12 August 2025

Our Ref: 2025/484587

Advice on Modification - Harbourside Shopping Centre Redevelopment – Podium and Tower MOD 6 - Construction Hours (SSD-49295711-Mod-6)

Figure 10: Internal Fit-Out, Services and Commissioning Works

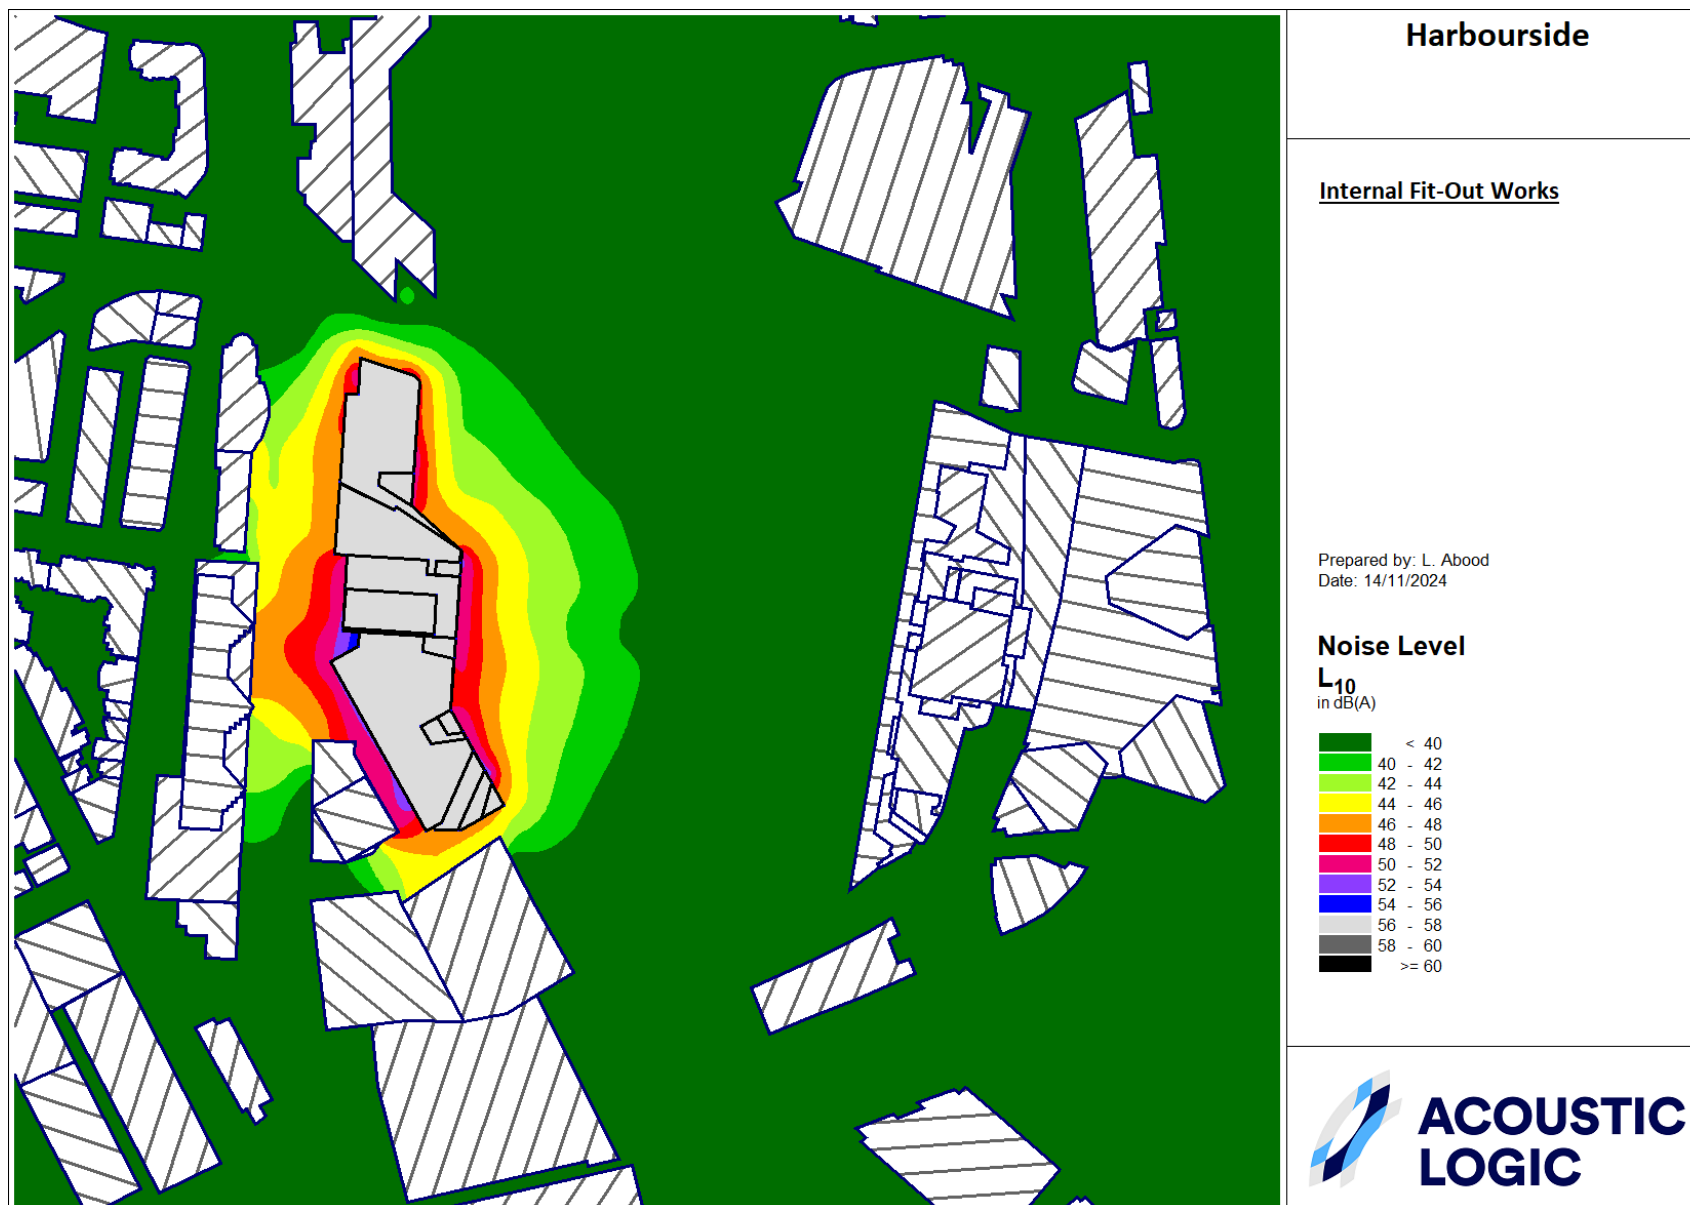
There are a high number of residential units located 100 metres away from this building, namely 129 Bunn Street, Pyrmont (221 residential units) and 117 Murray Street, Pyrmont (58 residential units). The proposed 24-hour internal construction is not recommended in this location as it will cause sleep disturbance to surrounding residents.

The acoustic report has predicted that some of these works may exceed the 'Noise Management Level' at the nearest receivers in this location.

It is therefore recommended that internal fit-out works be restricted to **between 7am and 10pm** to ensure City of Sydney Code of Practice for Construction Hours/Noise can be adhered to.
